SSD 61400212
AB7 (P&E)

STATE SIGNIFICANT DEVELOPMENT APPLICATION 61400212
APPLICANTS: Third.i Crows Nest Residential Developments Pty Ltd

Sheet title  
CARPARK LEVEL 05

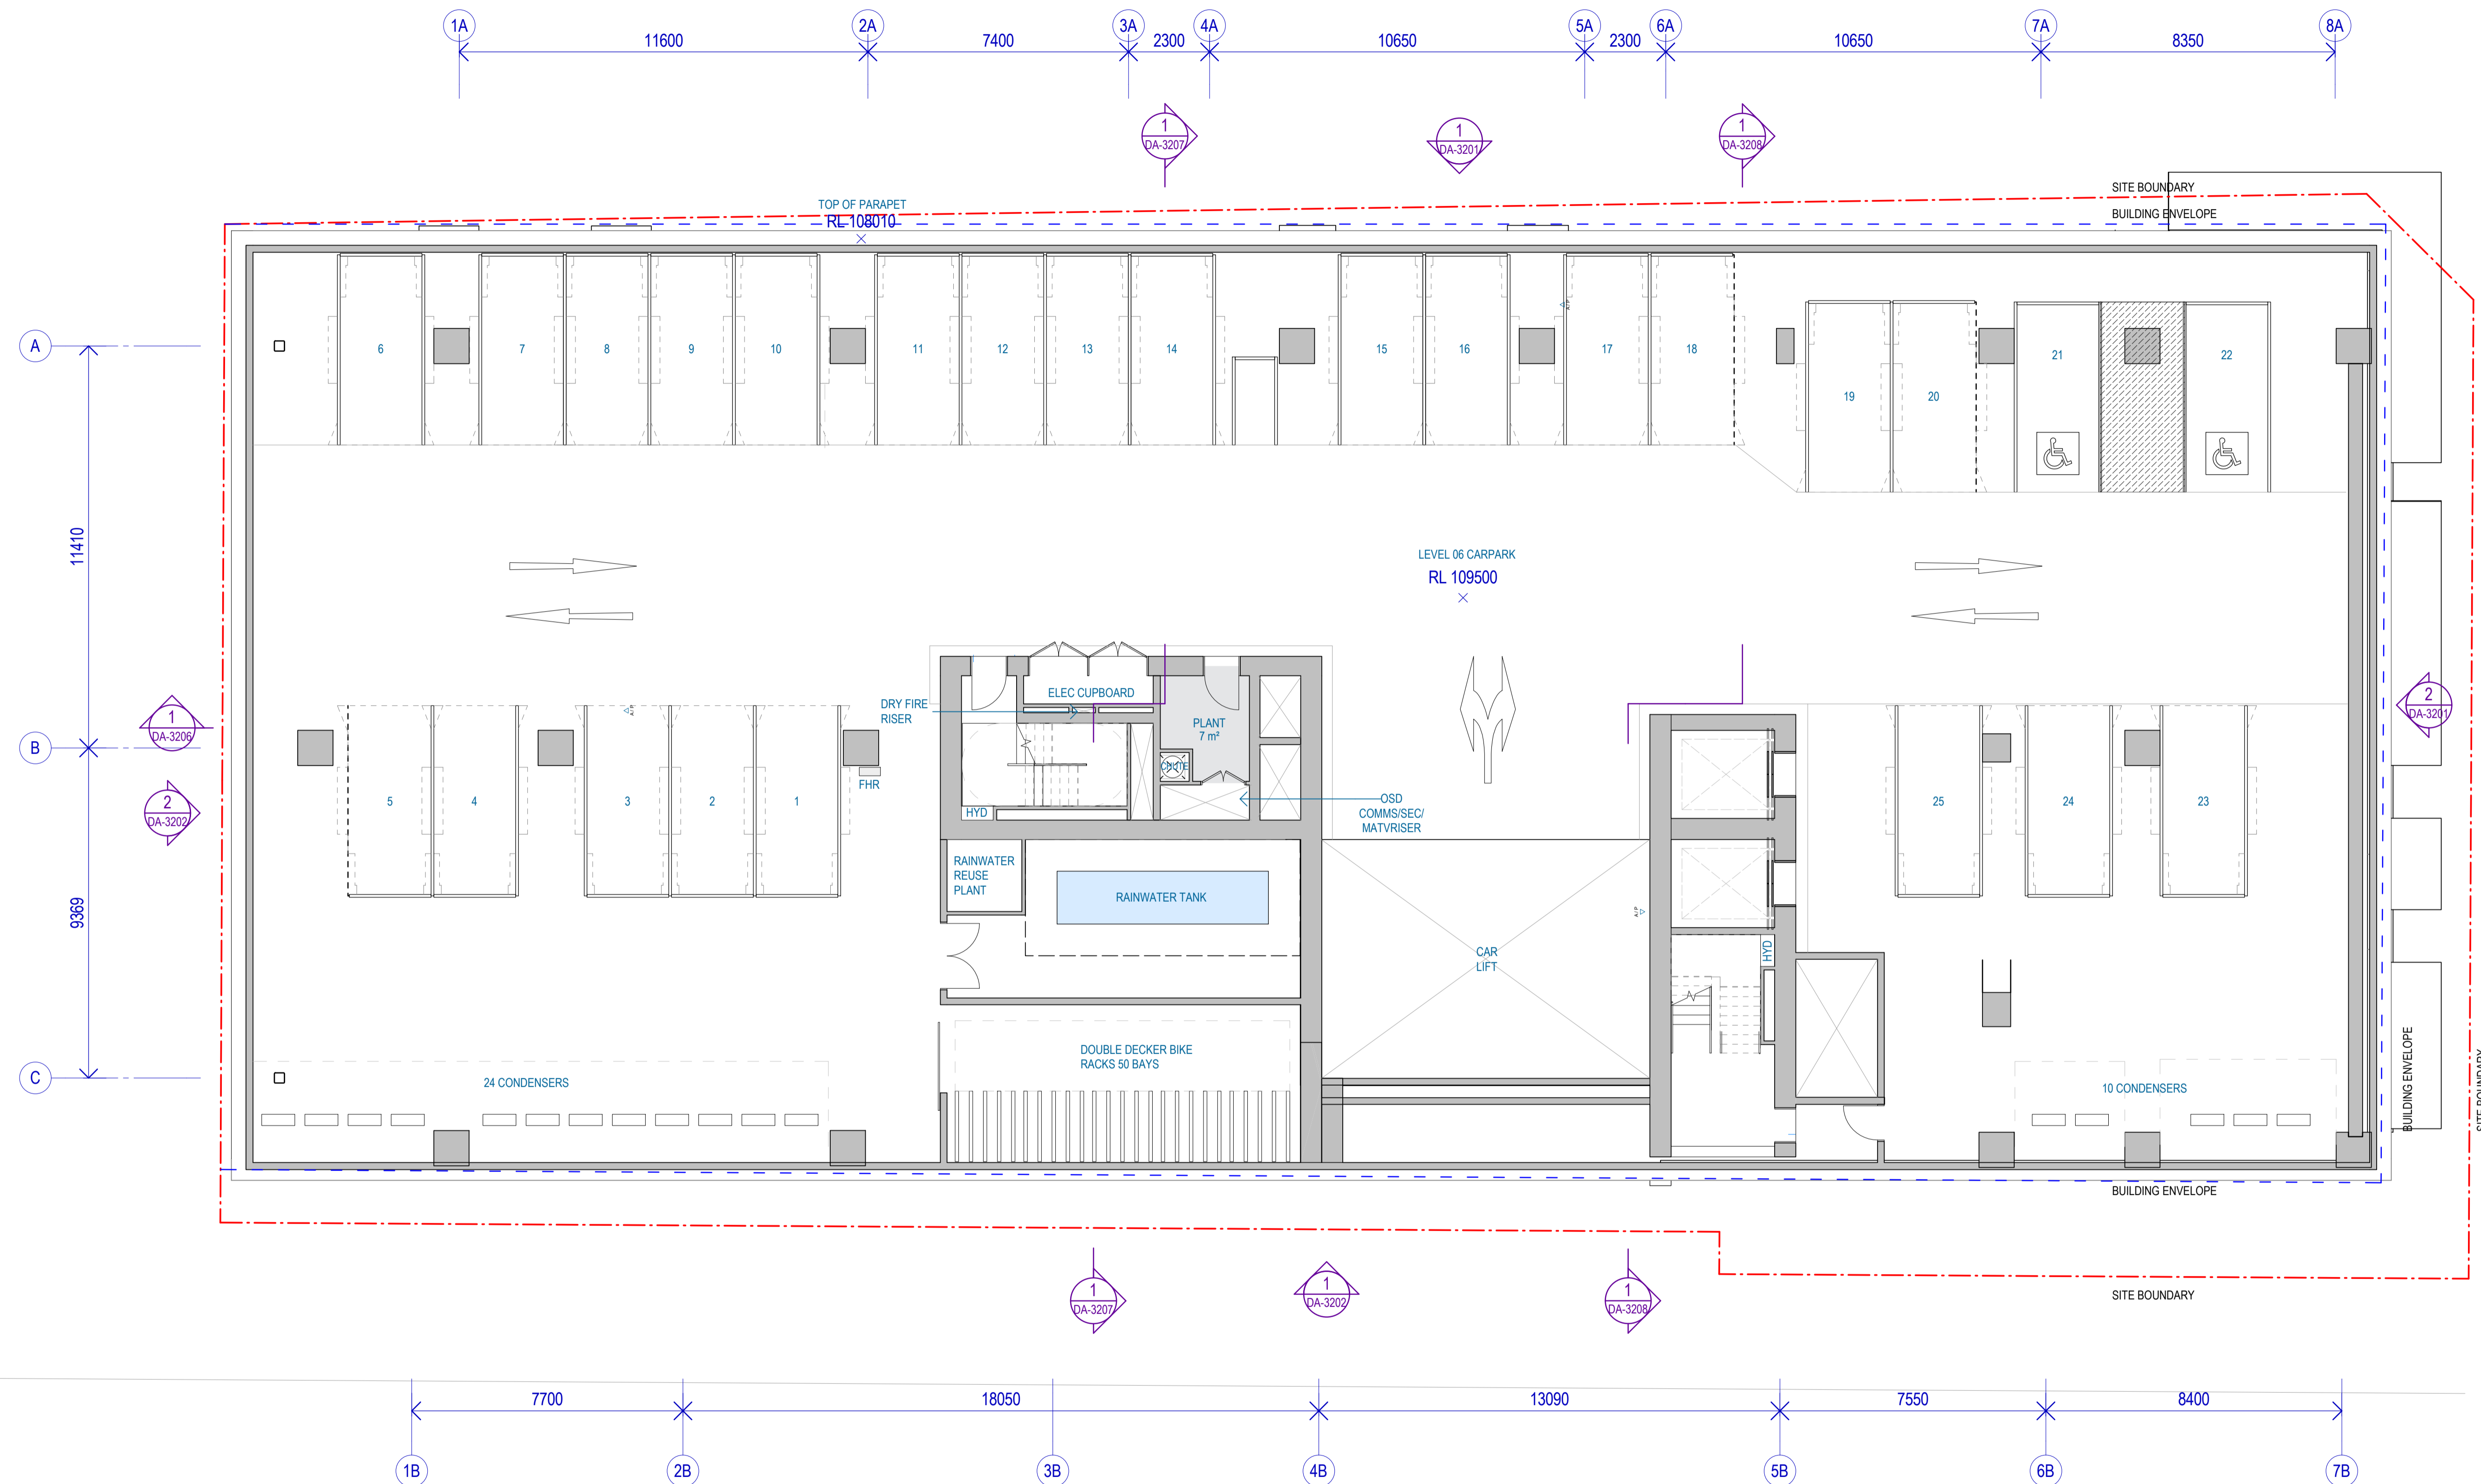
The proposed building includes two levels of car parking on Levels 5 and 6, with a direct open interface to the adjacent site to the south and a 0m setback to the shared boundary (Figure 7). The façade at this interface is designed as an open structure, featuring perforated metal panels.

The Crows Nest TOD planning recommendations indicate that the adjacent site is intended for redevelopment with a 3-storey street wall accommodating non-residential uses, with residential uses above. As such, the proposed open façade car parking levels with a nil setback at Site B will directly face future residential units on the adjacent site.

This design raises significant concerns, as it would have a detrimental impact on the residential amenity of the adjacent site, particularly in terms of privacy, noise, air quality and visual intrusion.

1 CLARKE LANE ELEVATION  
SCALE 1:200

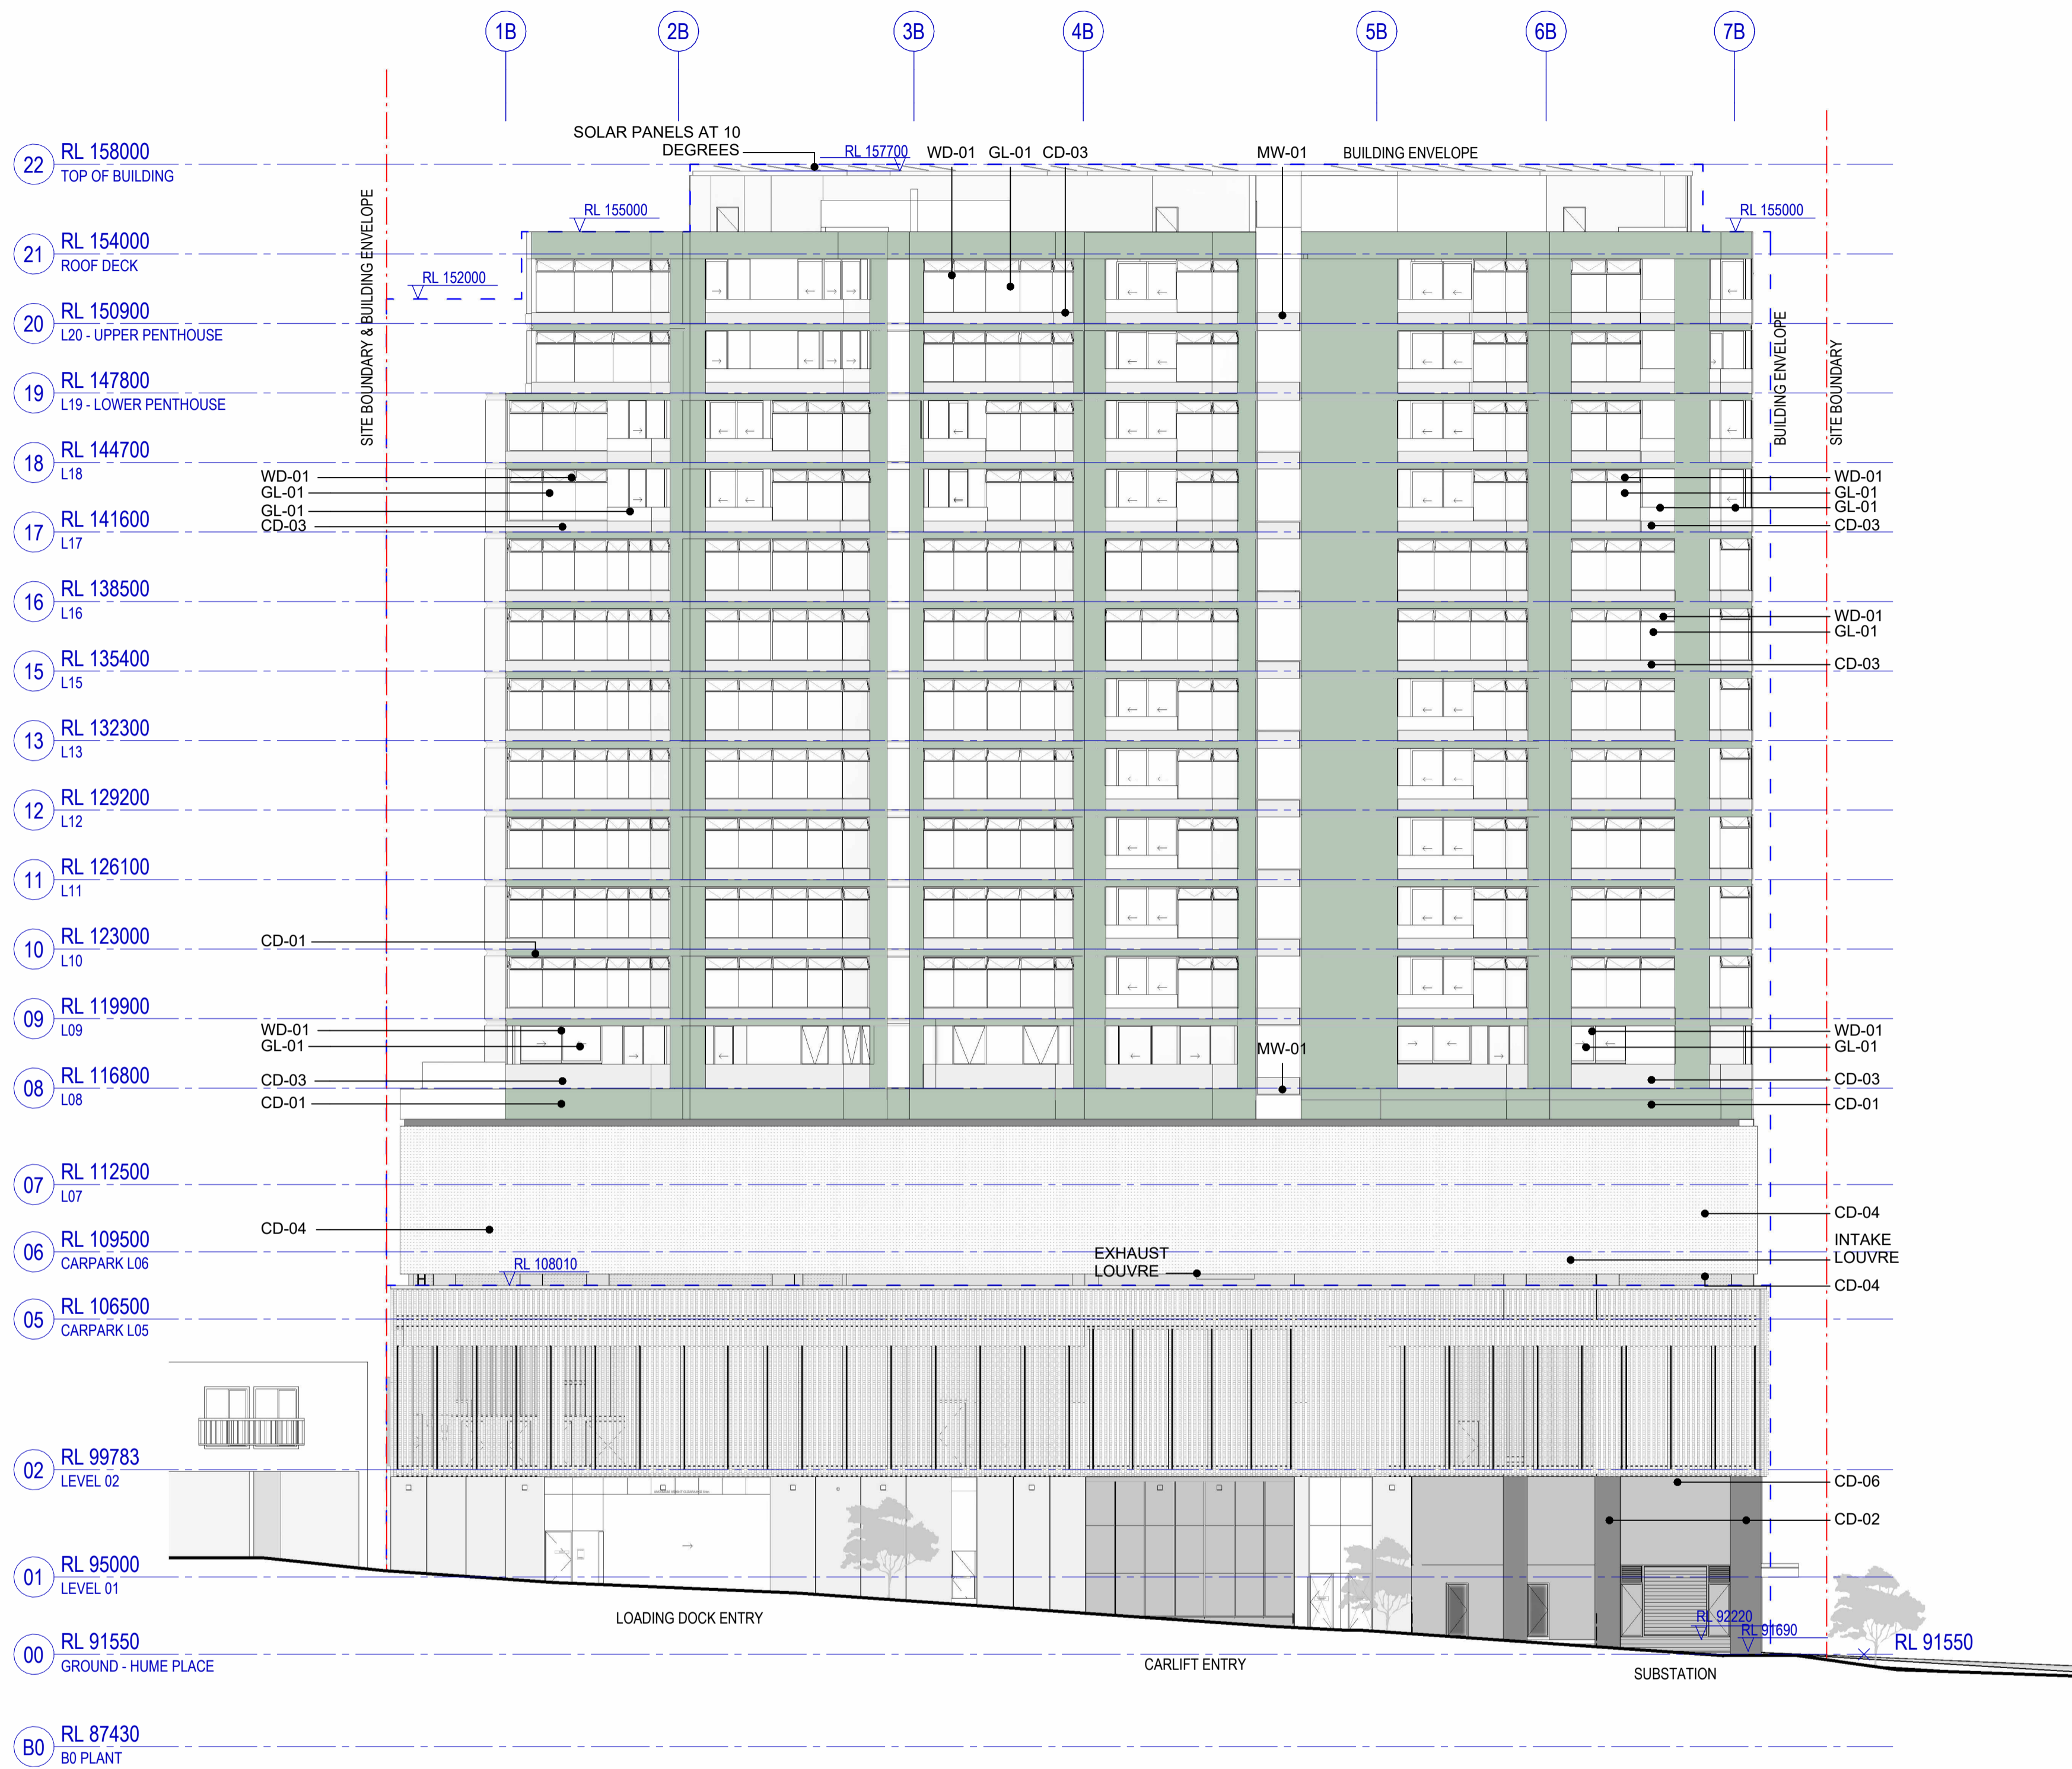
The ADG requires a total of 21m building separation between habitable rooms of Site B (18 storeys) and the site across Clarke Lane (potential 8 storeys). To comply with the ADG, a minimum 12m building setback should be provided from the centreline of Clarke Lane.

However, the proposed design only provides a 6m building setback for residential levels 9-20, which falls significantly short of the required minimum setback. This non-compliance compromises privacy, amenity, and the overall design quality for future residents on both sites.
